Project: Cammeray Seniors living

Address: 19 - 23 Rosalind Street Cammeray NSW 2062

Application: SSD - 96505456

Our objection to the proposed seniors living development at 19- 23 Rosalind Street Cammeray on the NSW planning portal. This reference is: SD-96505456

DRAWING TITLE
LOWER GROUND - PROPOSED PLAN
 DRAWING NUMBER
 DA-101
 REVISION
 A

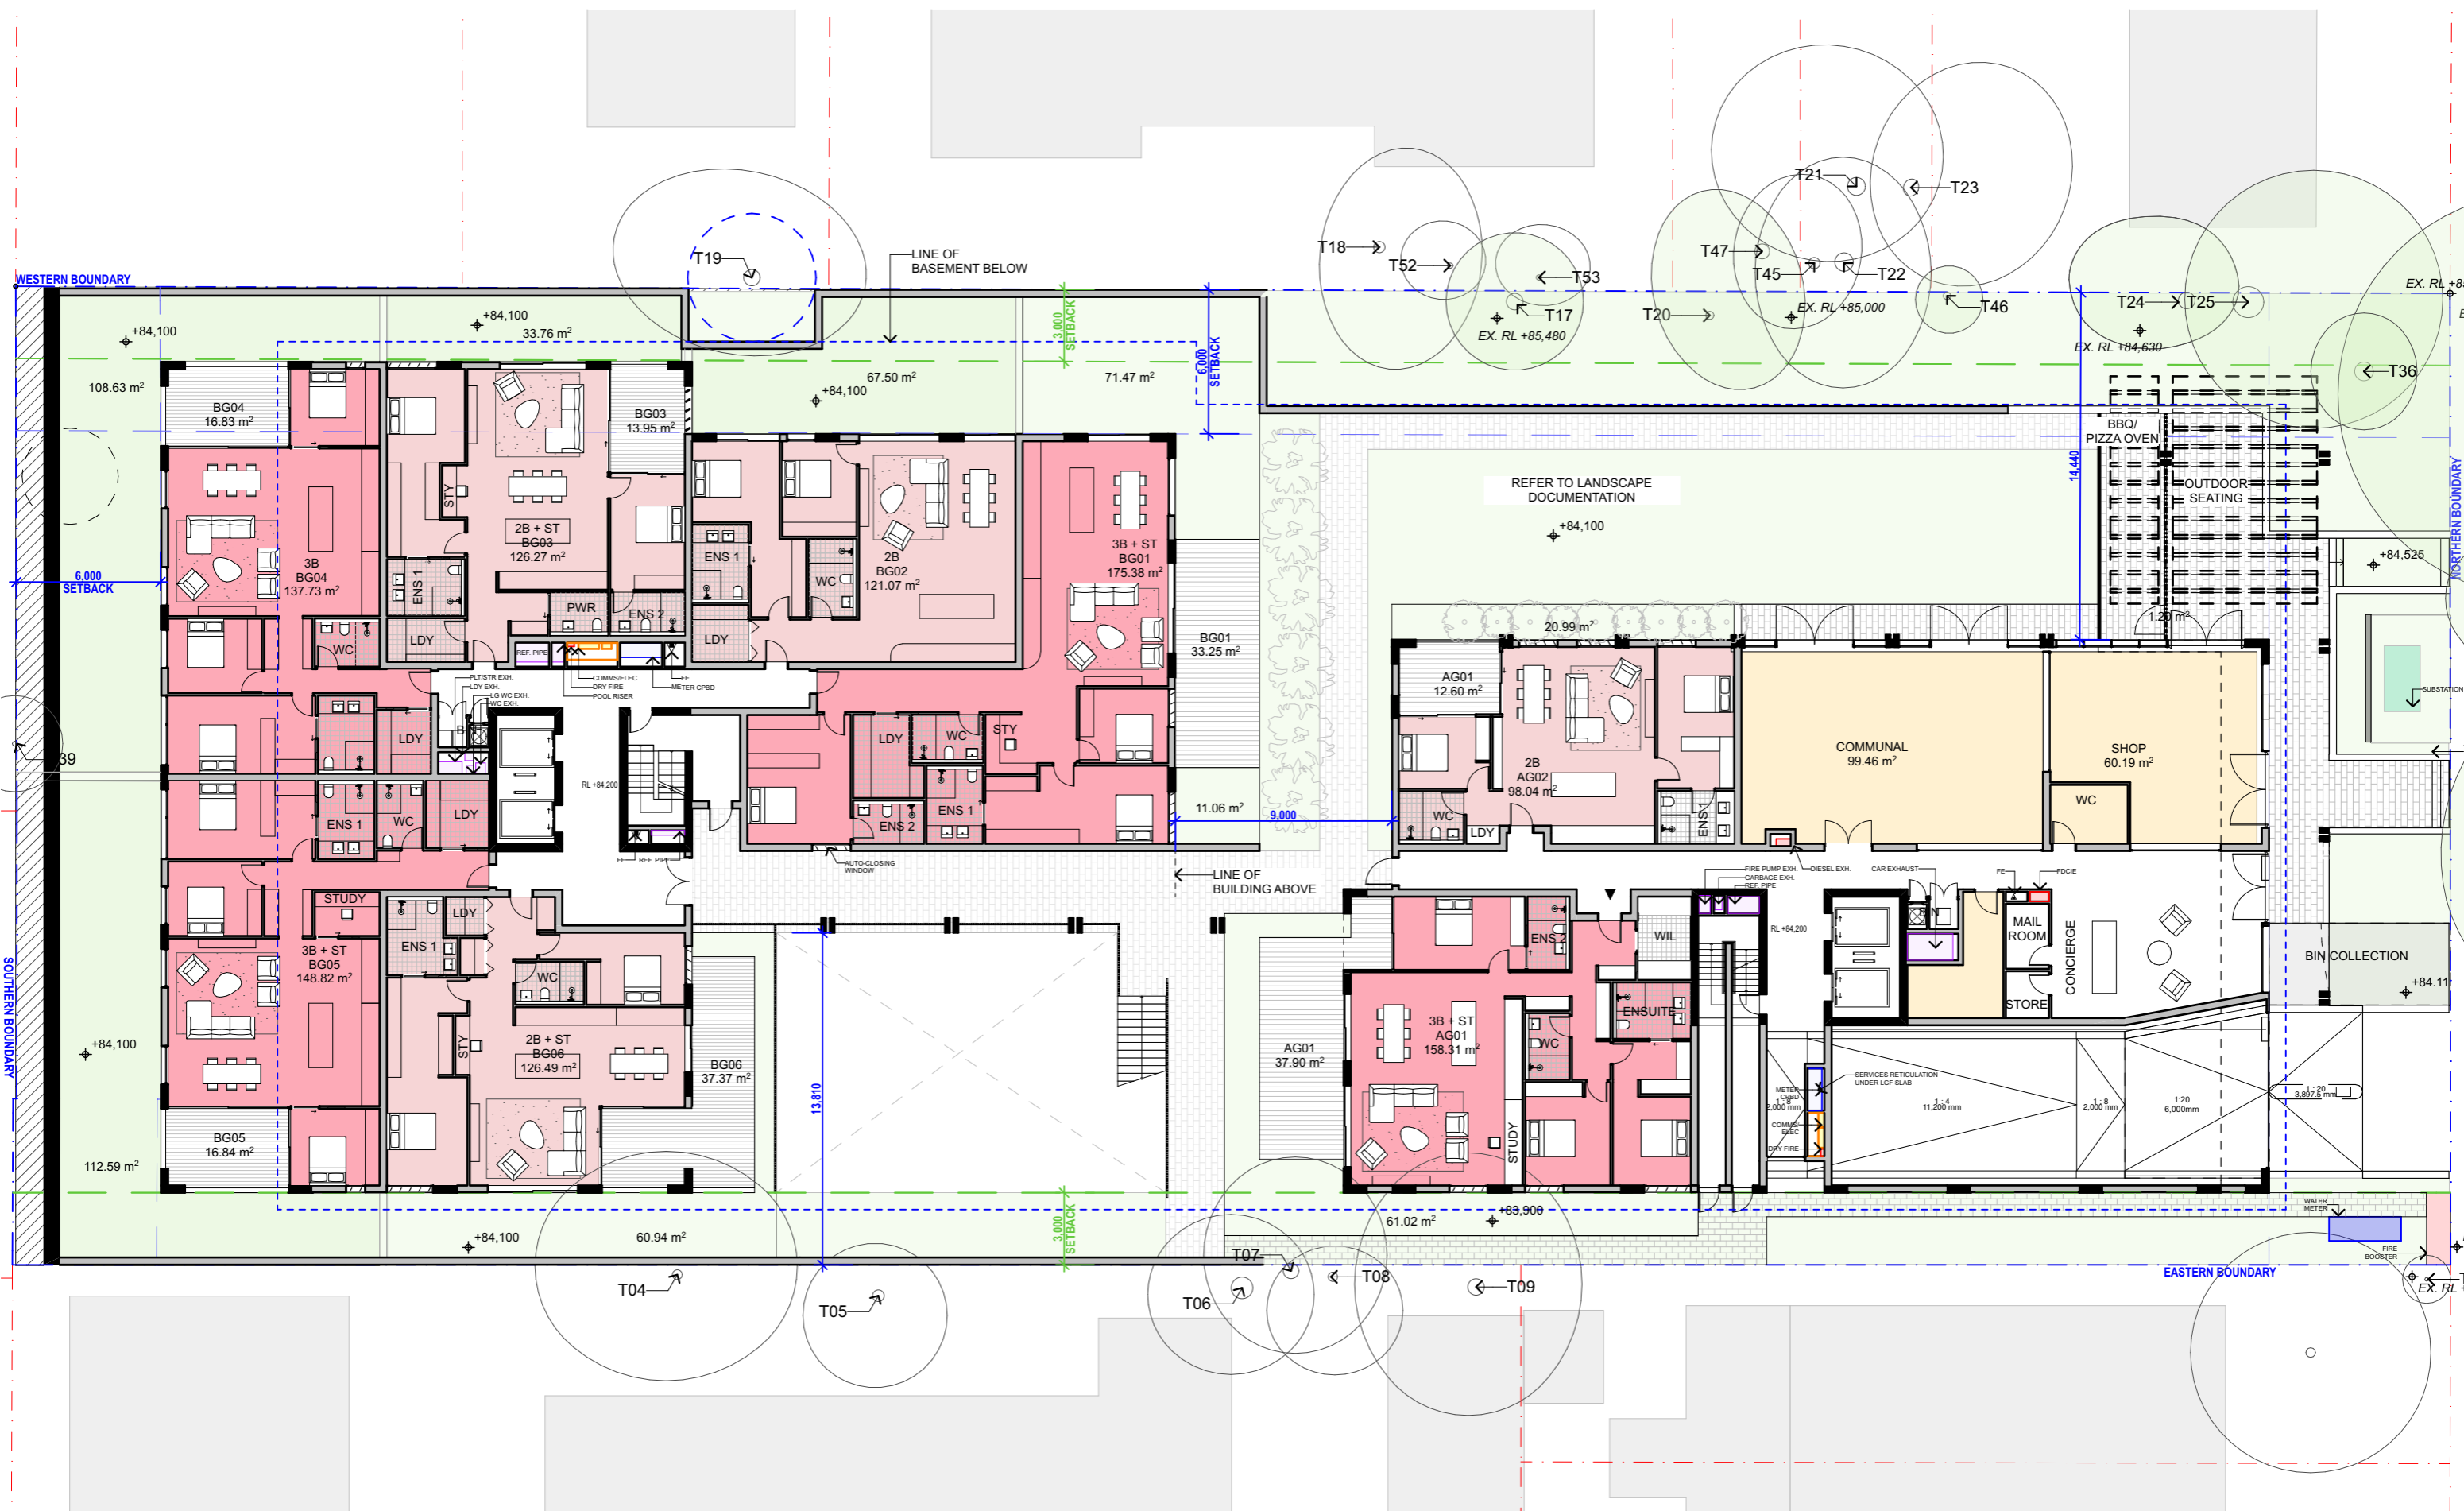
I object to the two care beds, both are located in the basement, despite this complex being promoted as a seniors living complex.

I object because the inclusion of care rooms underground appears non-compliant with NSC LEP. This should not qualify the development for the 25% FSR bonus.
